Planning

Our ref: MP 08_0257 & MP 08_0258

Major Project 08_0257 – Stage 1 Residential Development and MP 08_0258 – Early Works Package, 61 Mobbs Lane, Epping

ATTACHMENT 1

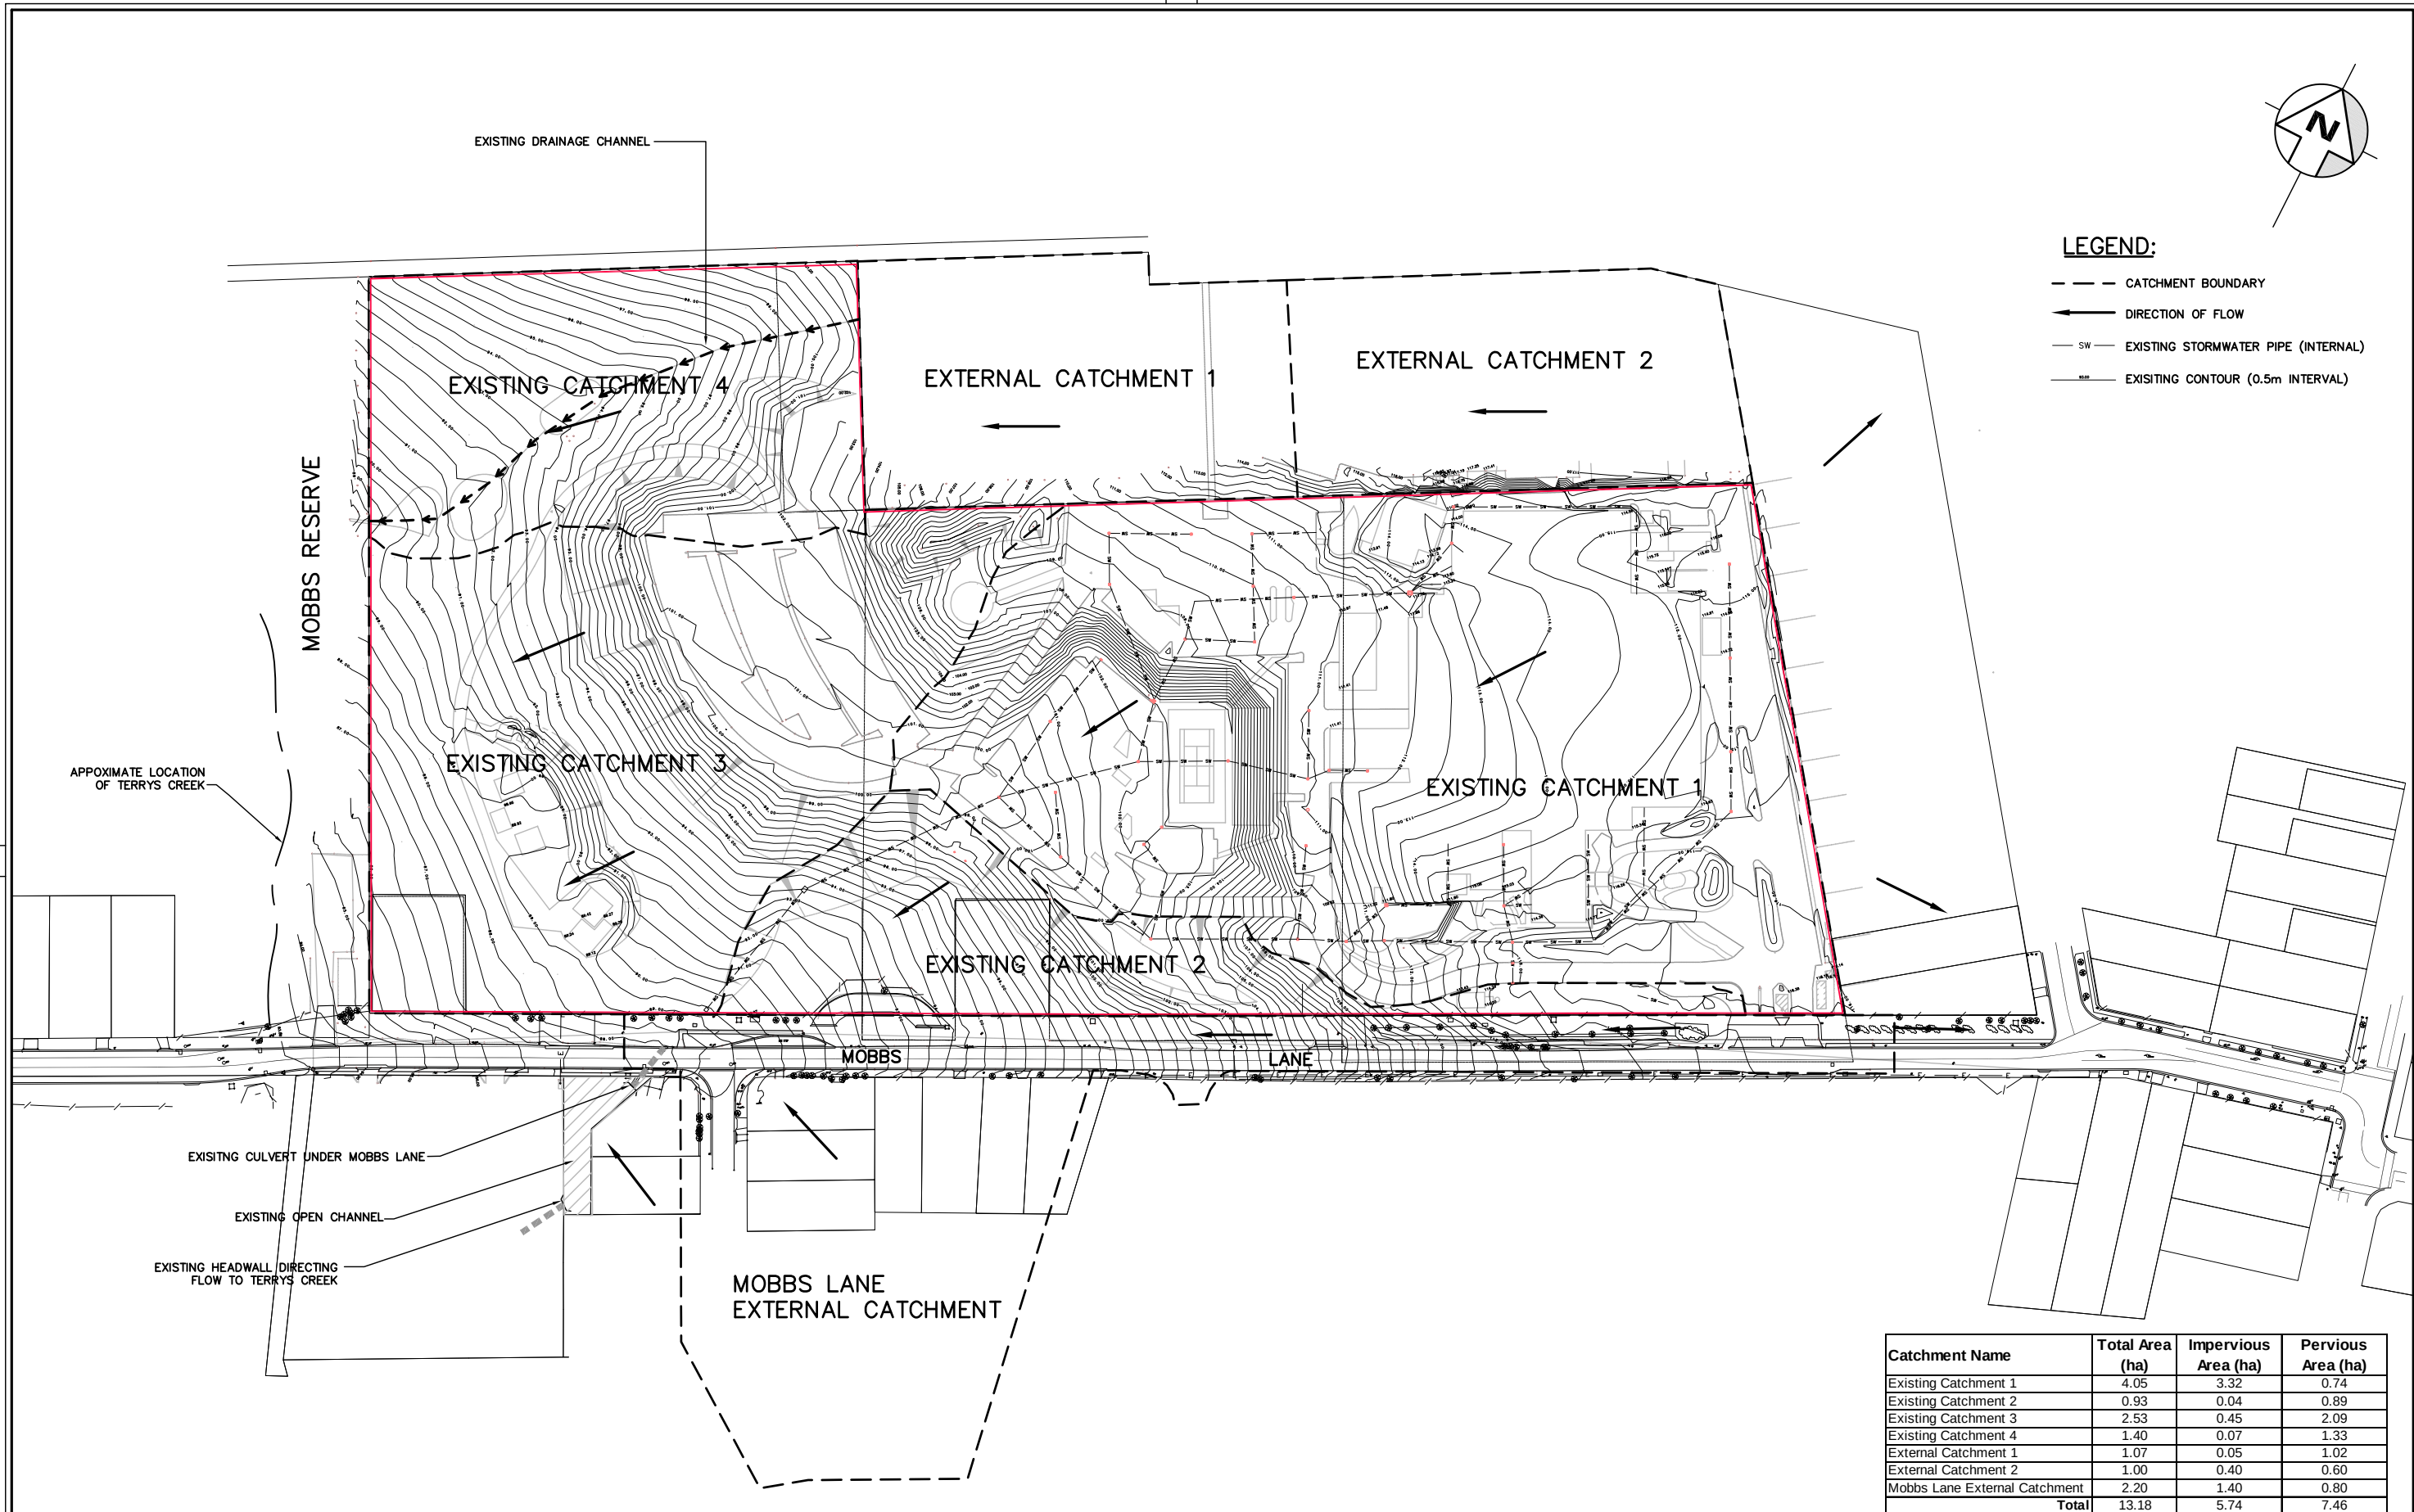
- The BASIX Certificates submitted as part of the application contain inaccuracies and should be amended. All plans are to identify BASIX requirements on the plans.
- Deep soil landscaping should be provided along the boundary between the TAFE and the proposed building as originally approved by the Concept Plan.
- All revised drawings are to be submitted at an appropriate/accurate scale, on A1 sheets. All elevation plans shall indicate existing natural ground levels and proposed natural ground levels.
